2023/1147

25 West Moor Crescent, Pogmoor, Barnsley, S75 2JY

**Demolition of existing detached garage, alterations, and extension to existing integral porch to form larger entrance and erection of canopy, erection of two-storey side and rear and single storey rear extensions, erection of 2-metre-high boundary wall, the creation of 2no. parking spaces to the front of the dwelling, and various internal alterations (Amended Description & Plans).**

PROPOSED FRONT ELEVATION
SCALE 1:100

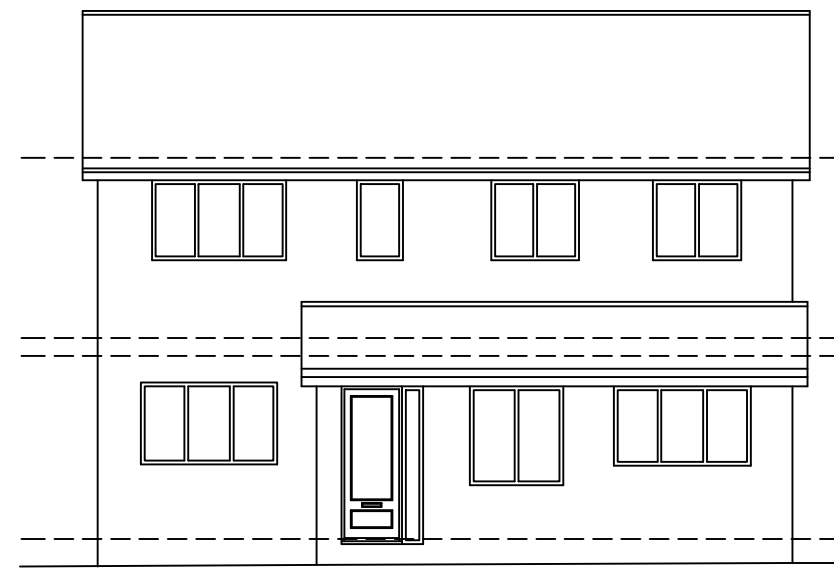
The proposed extension to the front of the application dwelling would adopt a sympathetic form and features, including scale and roof type that would mirror the style and proportions of front gable projections to some dwellings in the street scene and opposite the application site. The proposed canopy would be a continuation of a mono pitched roof to an existing extension that would be retained and integrated into the proposals and would cover the remainder of the front elevation of the existing dwelling and the front elevation of the proposed two-storey side extension. The front extension would be finished in render. Whilst this material is not prominently used throughout the street scene of West Moor Crescent, its use is not considered to be excessive and would be complimentary to existing external materials.

PROPOSED GROUND FLOOR PLAN
SCALE 1:50

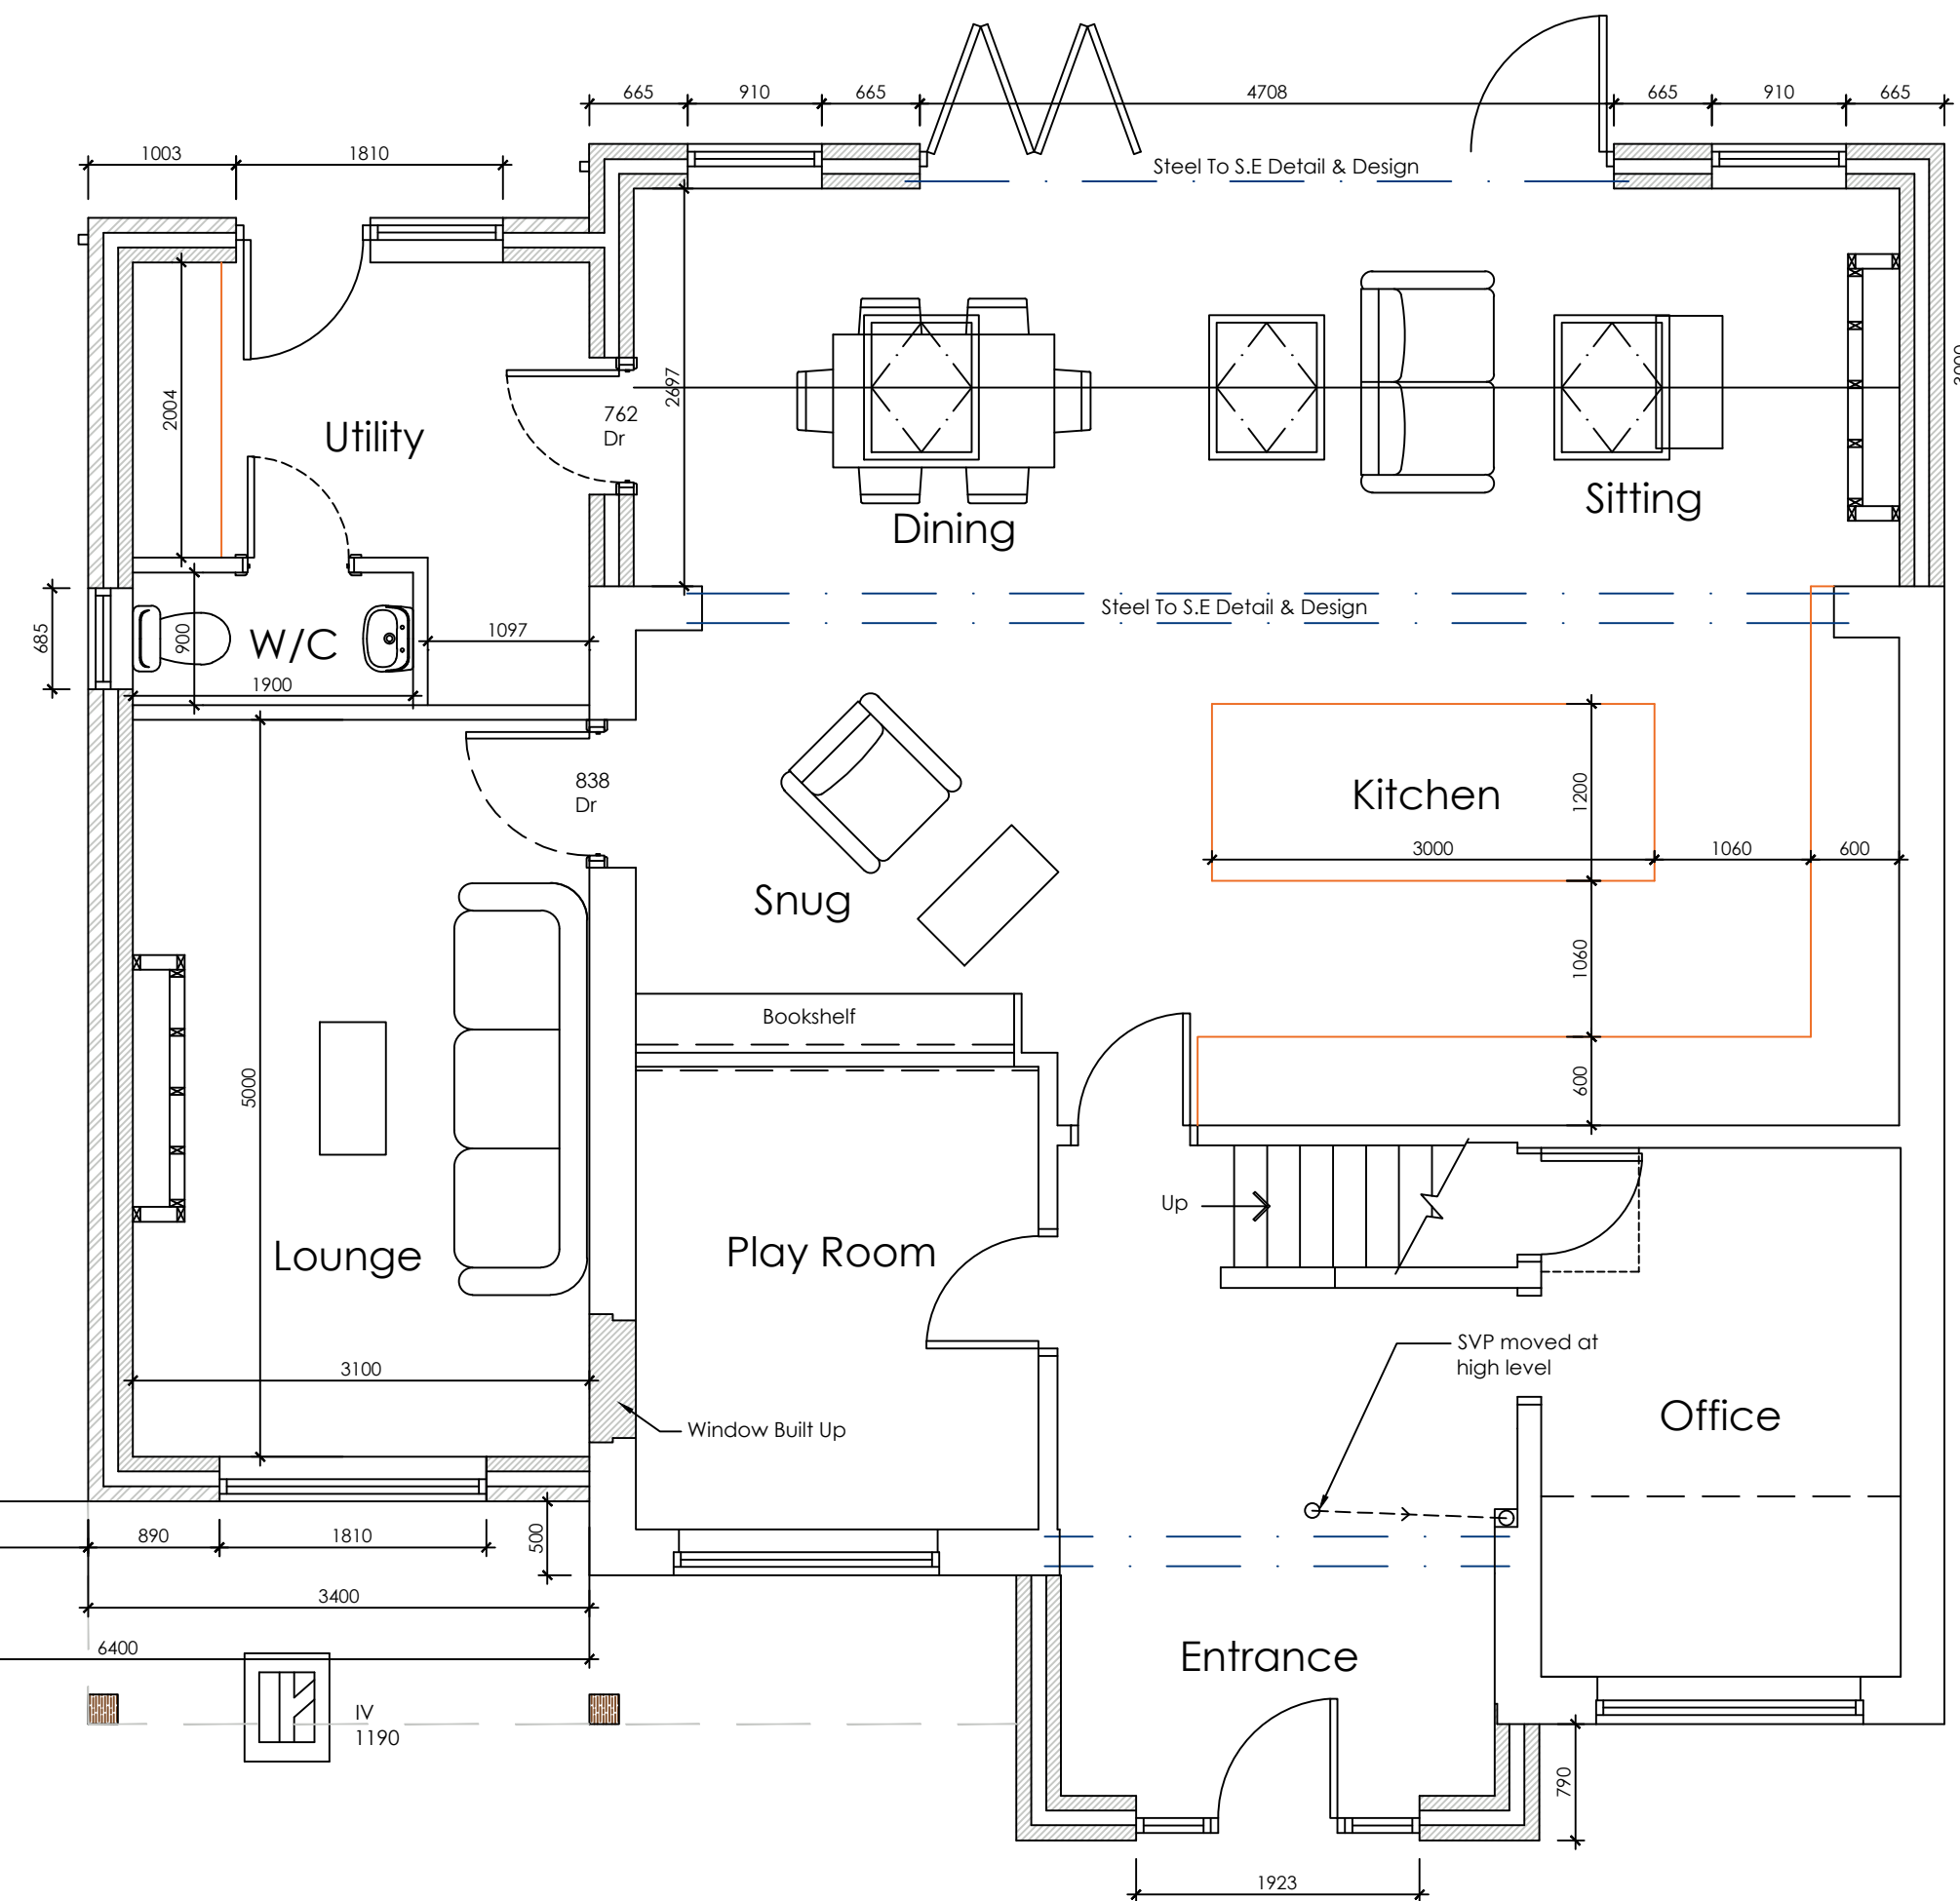
The proposed extensions would not be erected in immediate proximity of any surrounding neighbouring properties and are therefore unlikely to contribute to reduced levels of outlook. A proposed ground floor window located on the side elevation of the proposed side extension would be located opposite a proposed 2-metre-high boundary wall which could impact levels of outlook. However, the window would have a secondary purpose serving a non-habitable room (WC) and therefore it is not considered that the amenity of the occupants of the application dwelling would be significantly detrimentally impacted.

The proposals would include the demolition of an existing detached garage and the loss of an existing driveway to the south-east corner of the application site. However, the proposed creation of parking spaces to the front of the application dwelling would ensure that a minimum of two off-street parking spaces would be maintained, in accordance with the parking SPD. A new dropped kerb would need to be installed to enable lawful access from the highway of West Moor Crescent. Whilst the dropped kerb would not require planning permission as the highway is not classified, a dropped kerb licence will be required, and an informative will be attached to any forthcoming decision.

BLOCK PLAN
SCALE 1:500

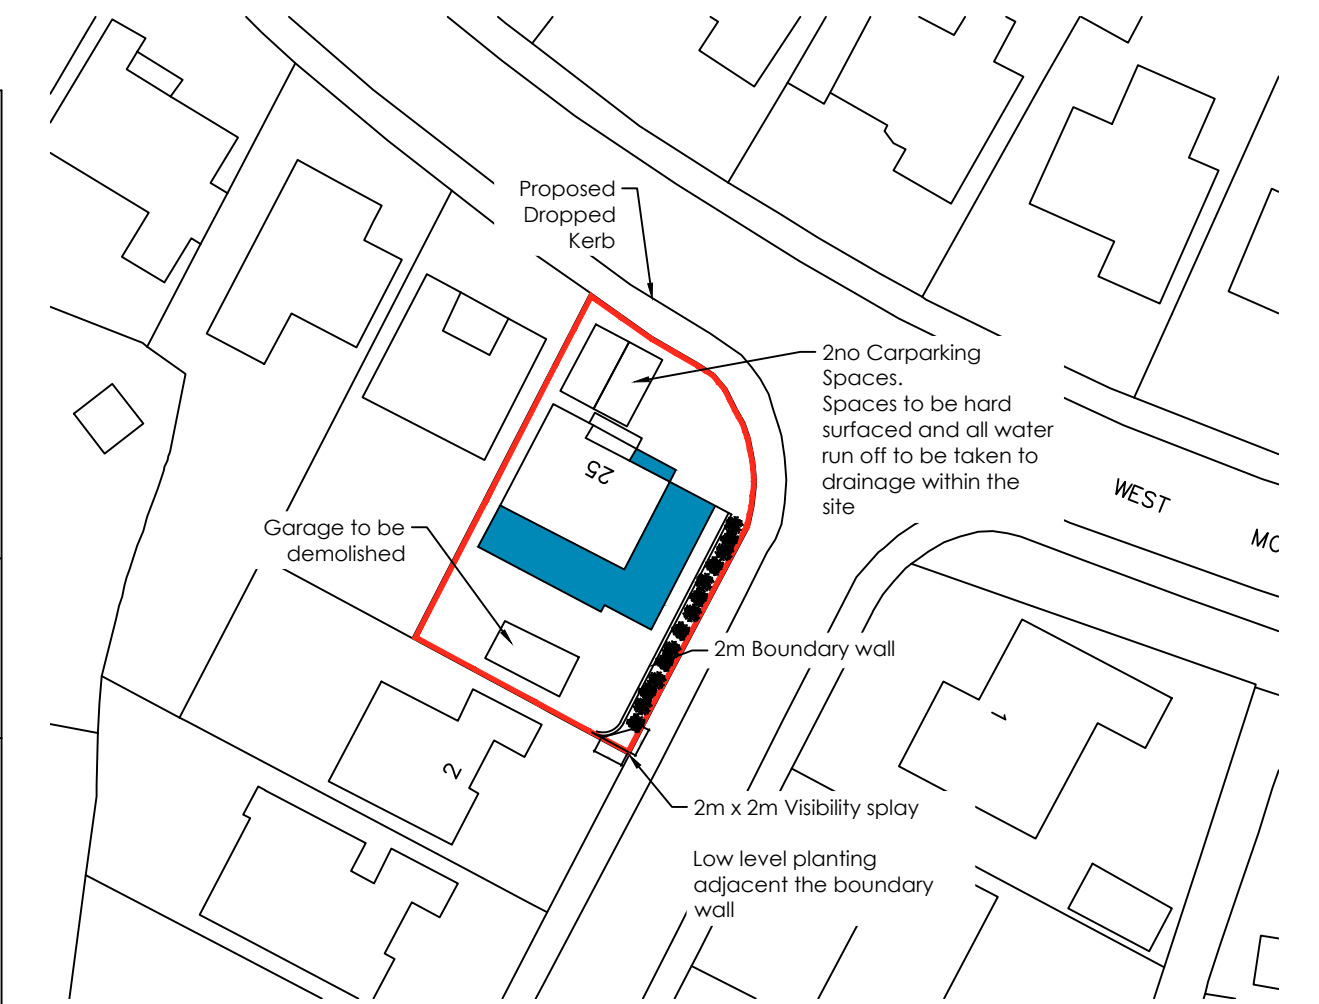
Highways DC – Given that the applicant proposes to set the boundary wall to the side of the property back more than 1m from the carriageway, it is likely that the 2m high wall proposed now falls under permitted development rights. I would suggest that the applicant ensures a 2m x 2m splay is on the side adjacent to the neighbouring property to maintain visibility and any planting should be low level.

- Concerned that the proposed boundary wall will obscure the view of traffic coming out of Midhope Way onto West Moor Crescent. There was a previous accident and regular parking near the junction occurs.

Concerns have been raised regarding the potential for the proposed boundary wall to obscure the view of drivers entering West Moor Crescent from Midhope Way. However, the proposed 2-metre-high boundary wall would be set back from back edge of the foot path by more than one metre and would not extend beyond the main front wall of the existing dwelling which is set back from the highway and the junction concerned. Moreover, as the extension would be set back from the back edge of the foot path by more than one meter, the wall could be implemented as a permitted development (therefore not requiring planning permission). Additionally, Highways DC were consulted and raised no objection, suggesting that the applicant should ensure a 2m x 2m splay is maintained on the side adjacent to the neighbouring property (2 Midhope Way) to maintain visibility and any planting should be low level. A block plan submitted shows that these suggestions will be implemented as part of the proposals.
